PERMIT

has permission to Interior renovations.

AT 242 ISLAND AVE P.I. 087 W006001

| Permit No: 06-0833 | Date Applied For: 06/06/2006 | CBL: 087 W006001 |

242 Island Ave. Peaks Island - 2nd Floor Proposed Scale 3/16"=1'

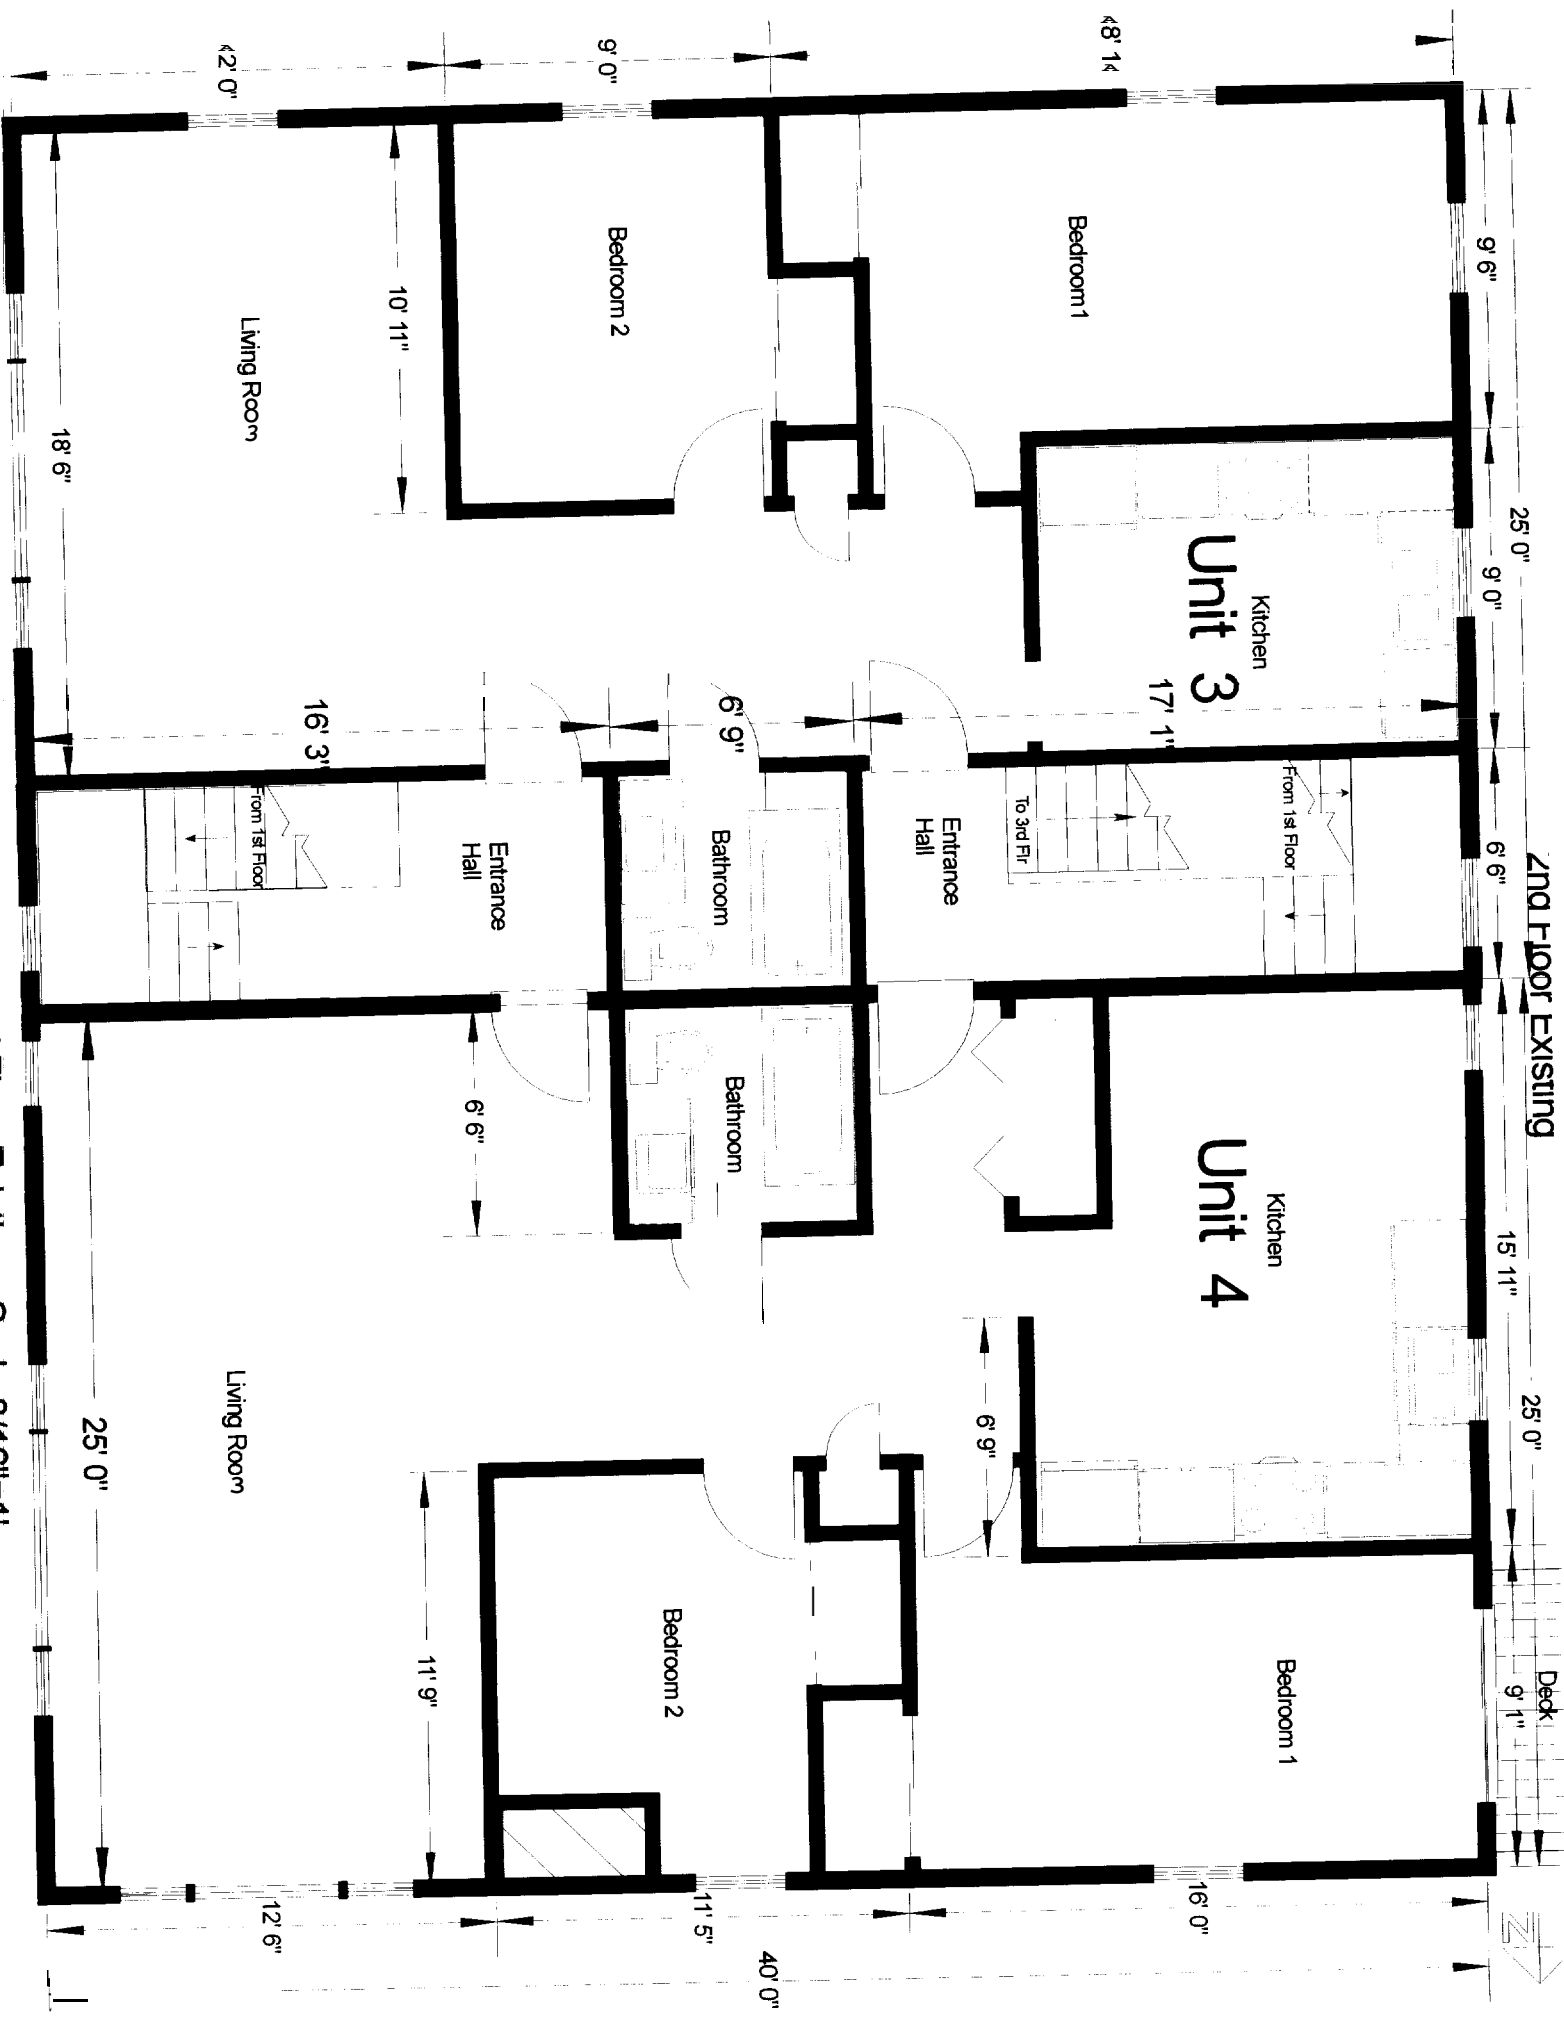
- 1) Each Sleeping room must have one egress sized window (5.7 sq. Ft. Net opening of one sash) with a sill height of less than 44 inches.
- 2) All partitions and floor ceiling assemblies that separate dwelling units from dwelling units or common areas must have a One hour fire resistance rating and a sound transmission class of 50. All penetration must be protected in accordance with chapter 7 of the 2003 IBC.

7/10/2006-mjn: Left with owner, need much more information. Met w/ owner agreed to Egress windows And Fire ratings and STC's
